**KIRKLEES METROPOLITAN COUNCIL
INVESTMENT & REGENERATION SERVICE**

**DELEGATED DECISION FOR DISCHARGE OF CONDITION -
NOTIFICATION OF A CHANGE OF USE UNDER THE ABOVE
PROVISIONS**

Reference no. 2026/CL/91505/W

Description	Prior notification for change of use of agricultural building to 6 dwellings and associated works
--------------------	--

BLOCK PLAN
1:500

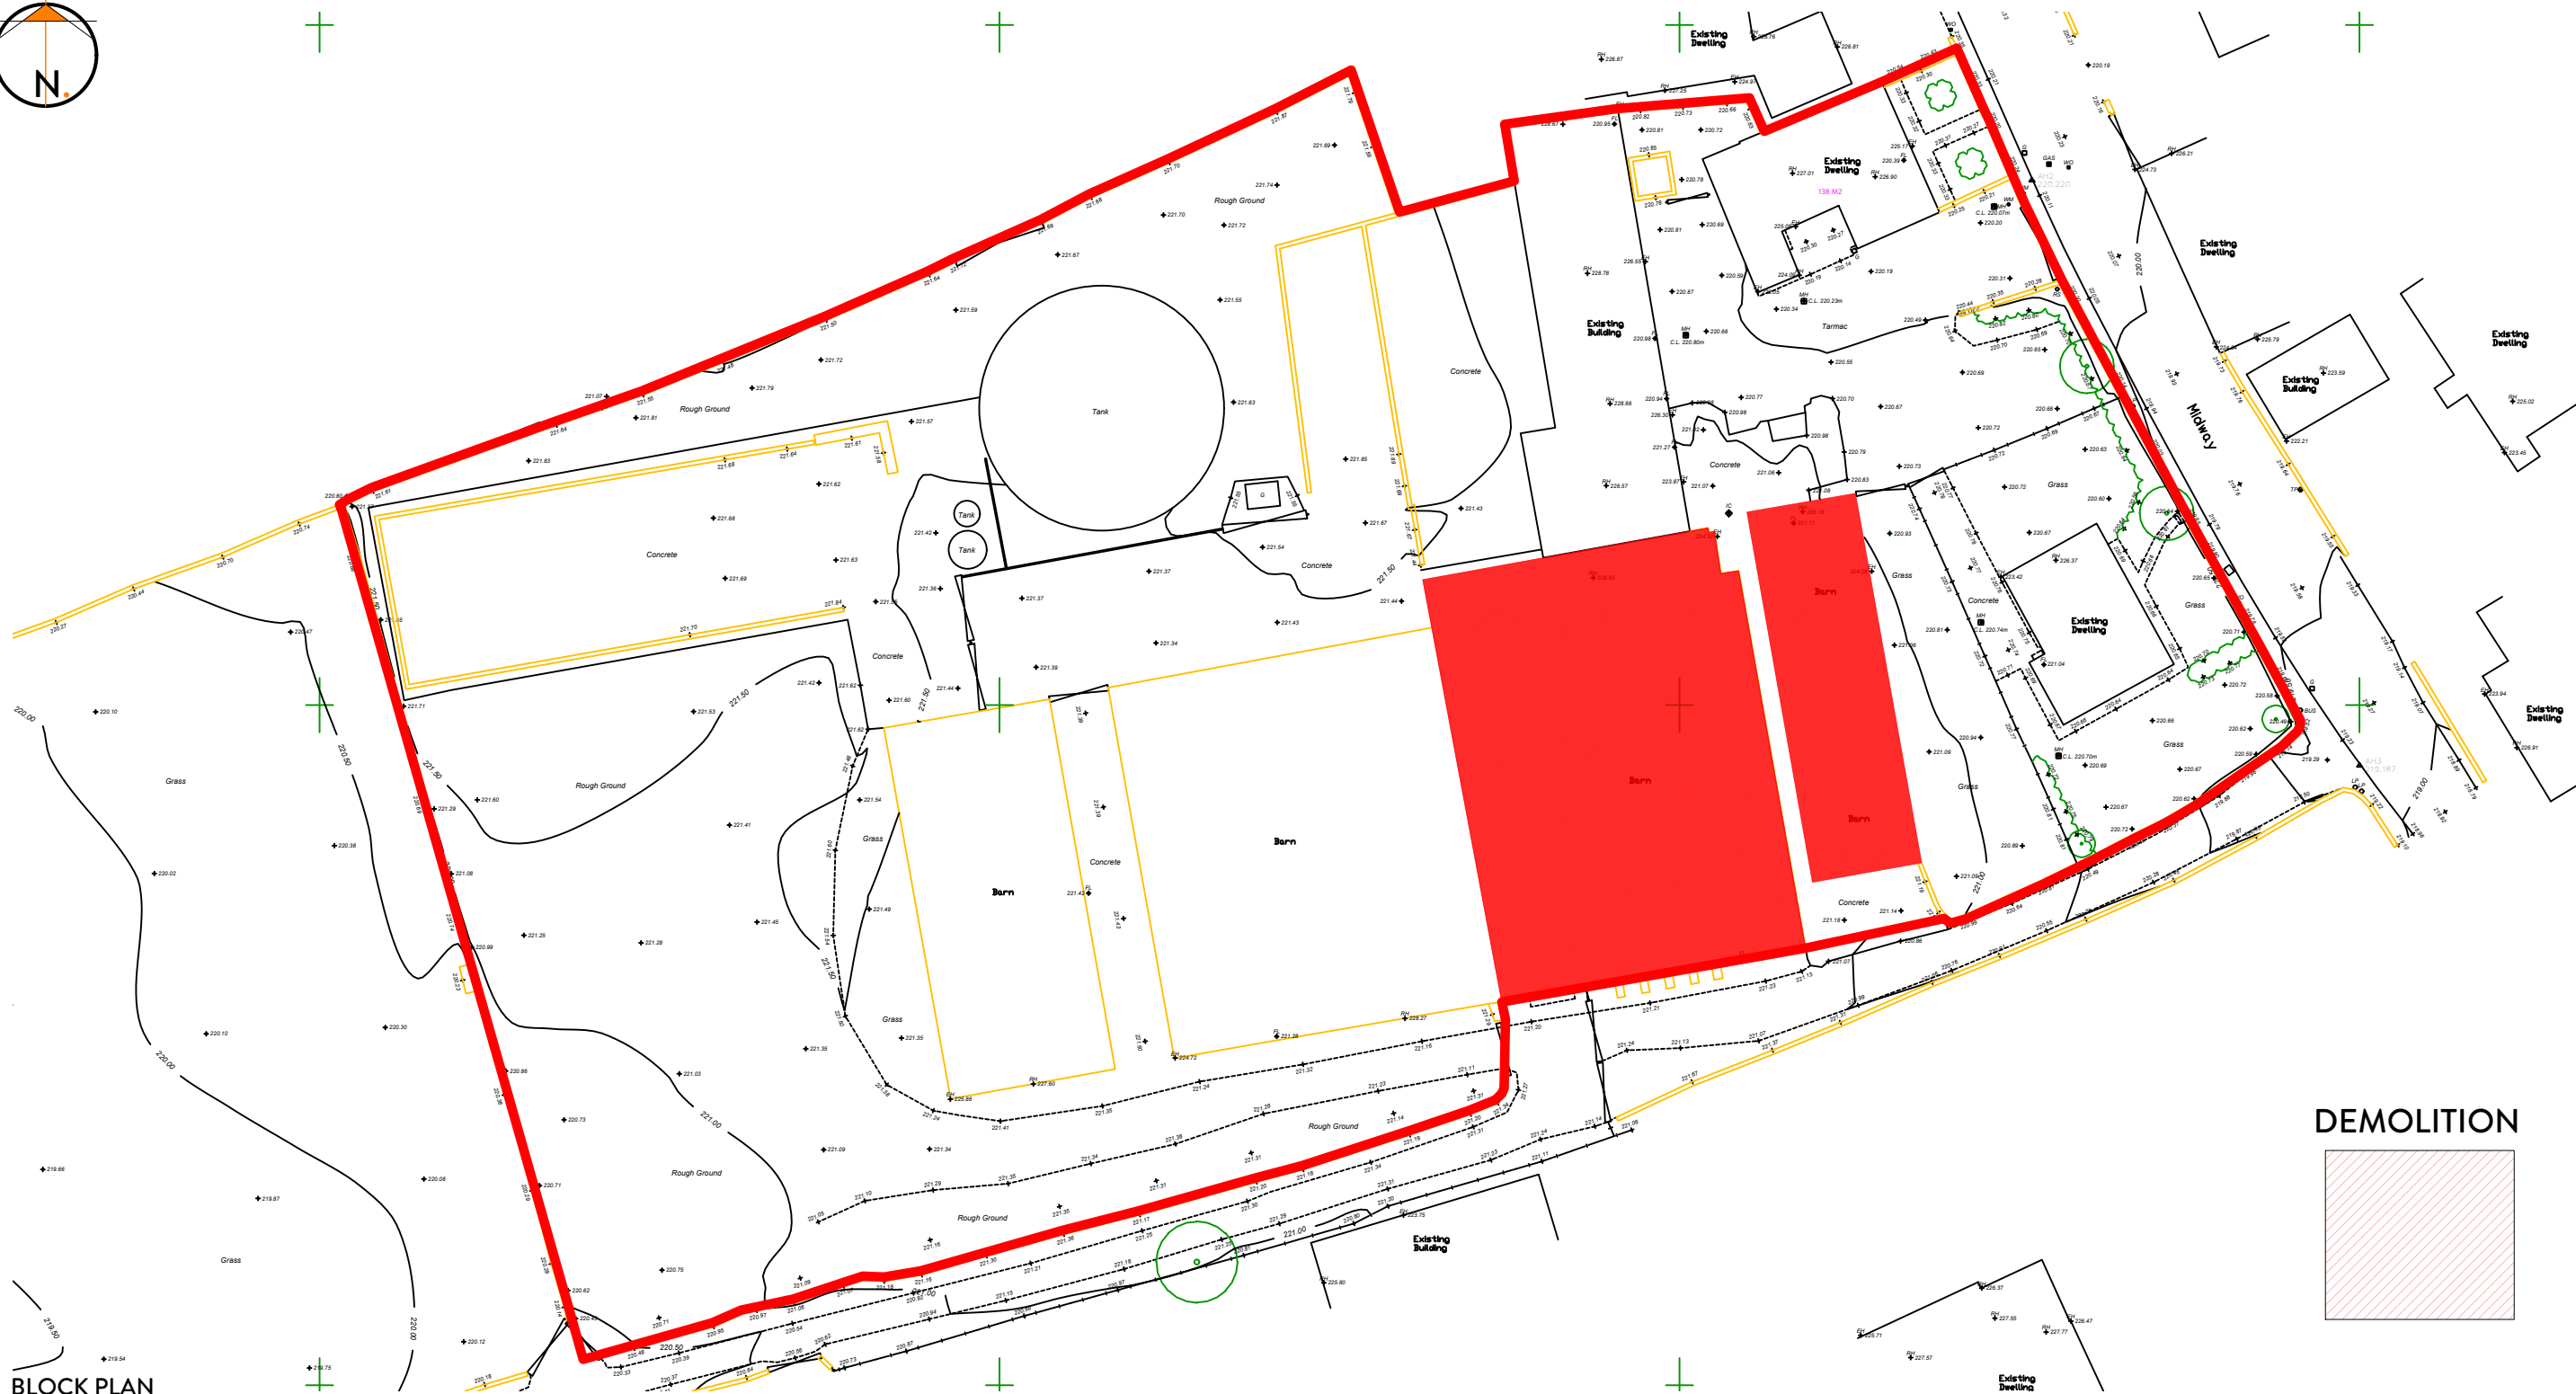
The accompanying Legal Advice Note indicates that the access will be across the existing hard-standing as shown on the proposed block layout drawing (reference no. (20)003), however, the red line boundary on the location plan has not been adjusted to indicate this. There is no indication within the cited planning appeals listed in the Legal Advice Note that the application sites covered did not have a red line boundary that connected to the adopted highway network.

The access is existing over a dropped kerb crossing and is currently used by farm traffic. It measures approximately 6m wide and this would be acceptable for two cars to pass. It is noted that the access is gated and officers would like to see either the gates removed or set back 5m from the rear of the highway to allow a car to pull clear of the highway while waiting for the gates to be opened and this should be conditioned.

No visibility splays have been submitted for the access. KC Highways DM would like to see visibility splays of 2.4m x 43m clearly displayed on a drawing. These should be to the nearside kerb and cross nothing greater than 1m in height. If these full visibility splays cannot be achieved then officers would be happy to see a reduction in the Y-length of the splay based on observed 85th percentile speed data obtained from an ATC on Midway and constructed to Manual for Streets calculations. This should be conditioned for highway safety reasons. Without this information officers cannot assess the safety of the proposed access.

The proposals are for 6 two-bedroom dwellings and to follow local guidance this would require 2 off-street parking spaces per dwelling with one visitor parking space per 4 dwellings. The proposed block layout (reference no. (20)003) shows that 12 resident spaces and two visitor spaces can be provided with suitable turning and manoeuvring space and this is acceptable.
